Application by Highways England for TR010031: A1 Birtley to Coal House Improvement Scheme

The Examining Authority's further written questions and requests for information (ExQ2)

Issued on 6 April 2020

Drawing Title COMPOSITE LAND AND WORKS PLANS
SHEET 2 OF 5
REGULATION 5(2)(i)

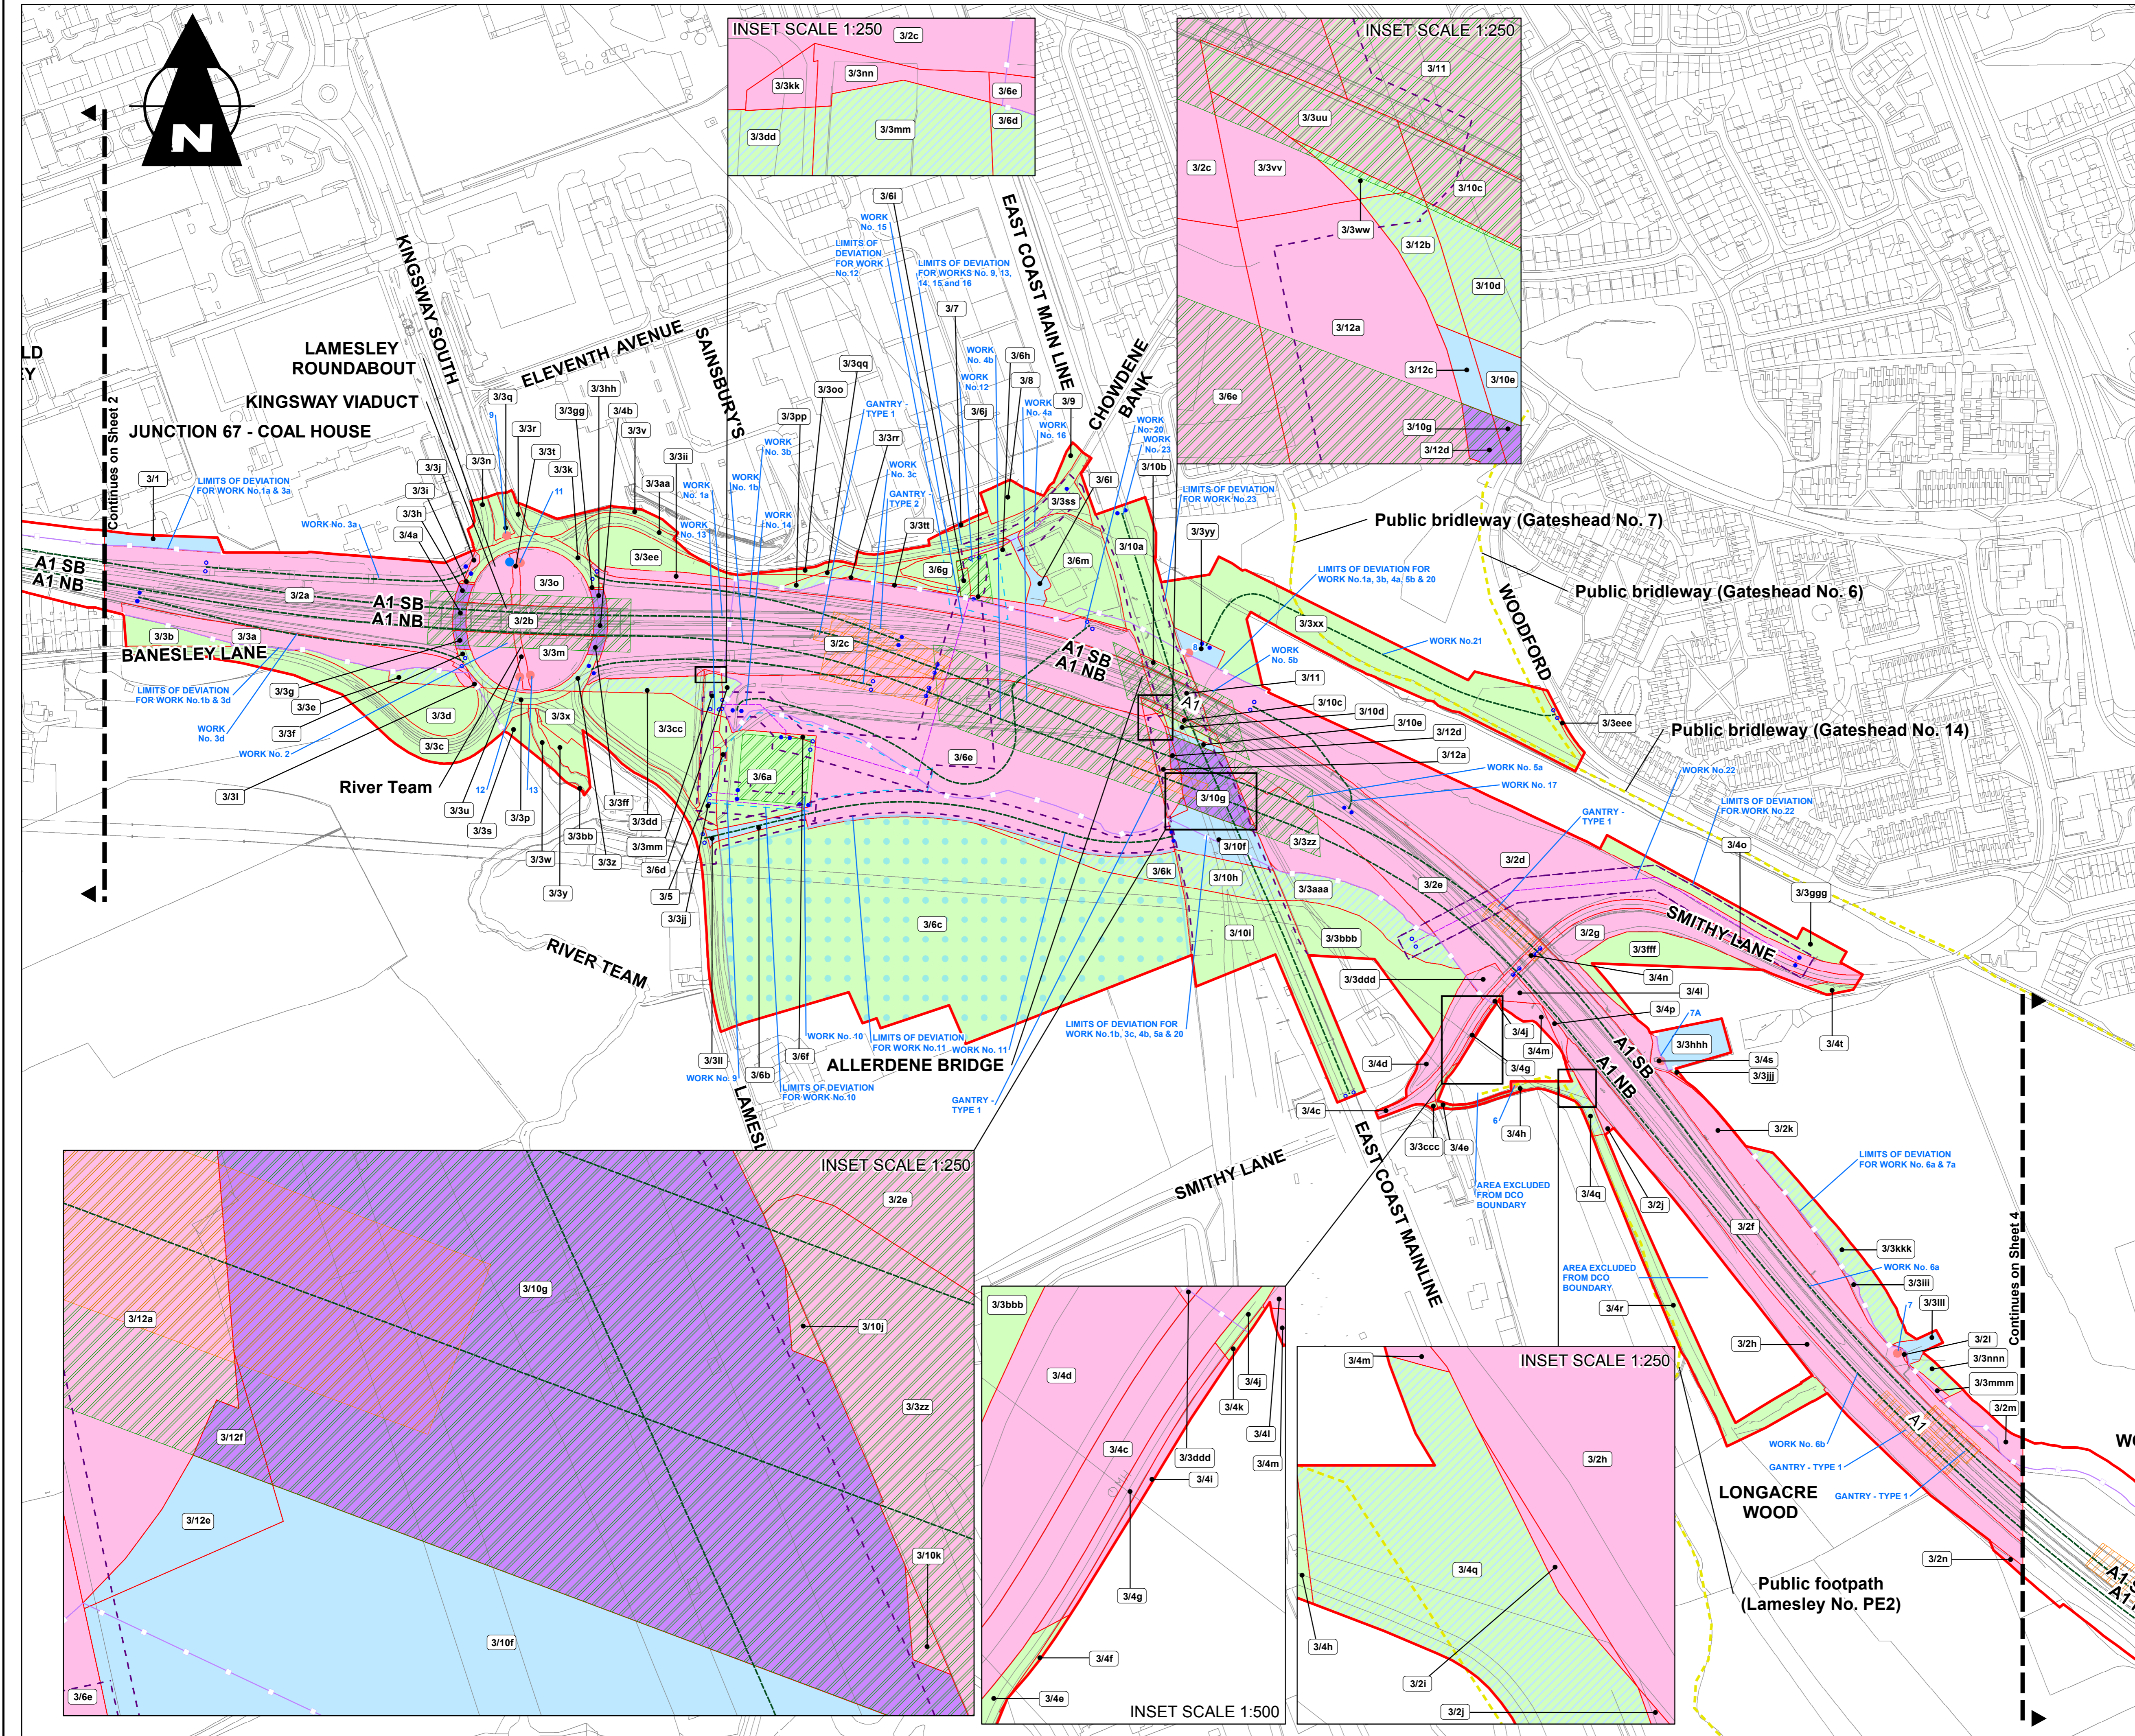
2.0.10	Applicant	<p>Sheet 3 of the Works Plans [APP-007] includes the Limits of Deviation for a) Works Nos. 9, 10, 13, 14, 15, 16 and b) Work No. 22.</p> <p>Please provide justification for the extent of land within these Limits of Deviation?</p>

Fig 1. CNG Site (Shown in Red)

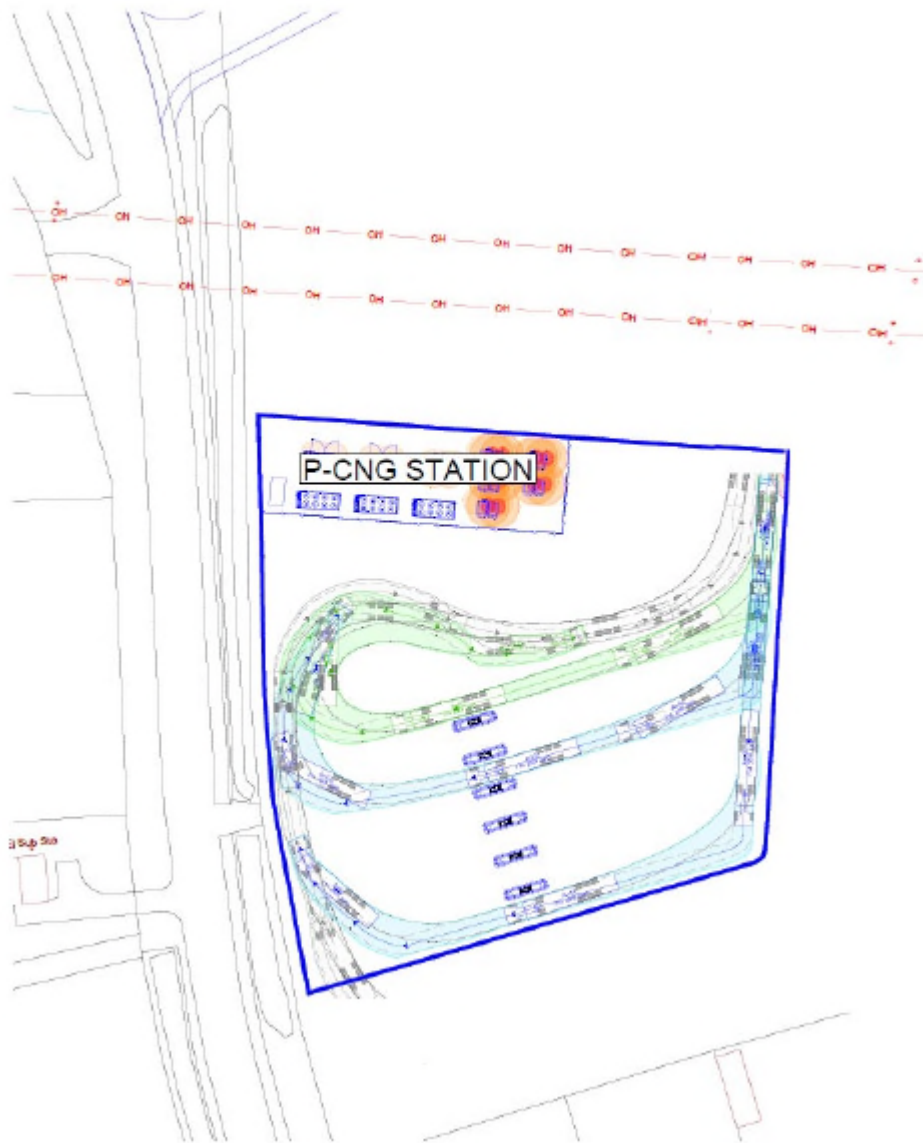
ExQ2	Question to:	Question:
2.3.4	Applicant and Northern Gas Networks Ltd	<p>Northern Gas Networks Limited (NGN) have submitted representations [including REP1-019] regarding the Applicant's proposed use of Plot 3/6c for a construction compound.</p> <p>a) In the light of such representations from NGN, the Applicant is requested to provide a full justification of its need for the entirety of land within Plot 3/6c, supplemented by any up to date drawings of the construction compound layout.</p> <p>b) NGN is requested to provide details of the proposed timetable for each stage of the implementation of the Compressed Natural Gas refuelling station, taking into account the design, planning and construction process.</p>
